From: Anita Gardner
Sent: 14 January 2019 14:46
To: Planning.Responses
Subject: FW: R/270/18/PL - Palm Cottage, 62 Ash Lane, Rustington
Attachments: 2376_01_02.pdf

Scales: **1:50 1:500** **No:** **2376/01/02**

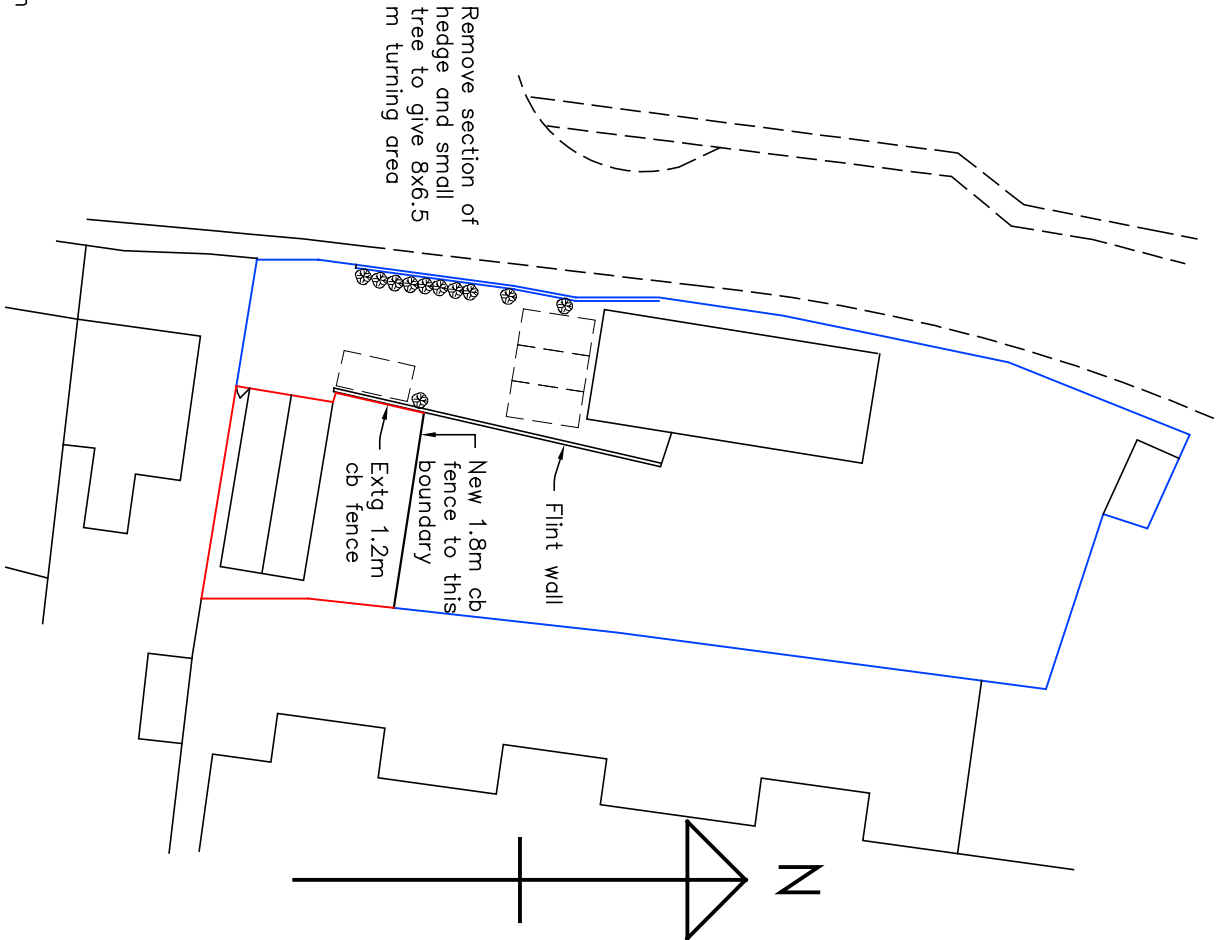
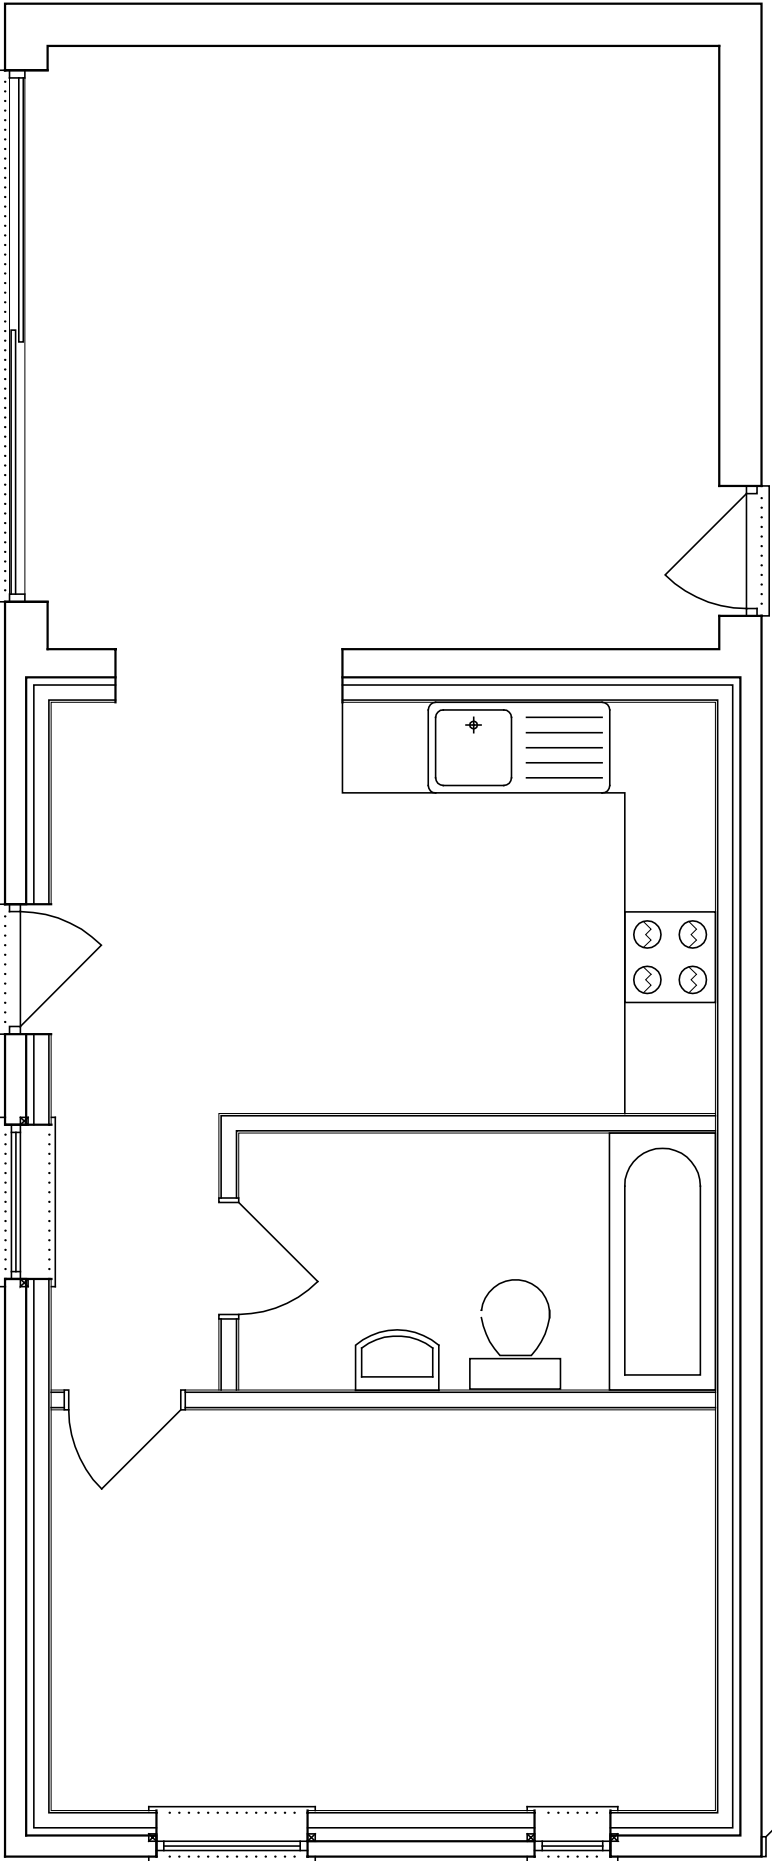
I refer to the above application. The proposal seeks conversion of the existing garage which decreases the parking available and increases parking demand at the site. I would therefore appreciate confirmation as to where/how the existing and proposed car parking demand will be met within the site. To allow for receipt of this additional information/ plans I would be grateful if you would agree to an extension of time on the application until 23-01-2019.

See attached revised block plan showing proposed parking spaces. The garden is a minimum of 8m wide with some 16m between the buildings so there is space to park at least 4 cars and allow for a turning area. If some of the hedge and 1 tree are removed then the turning space is improved.
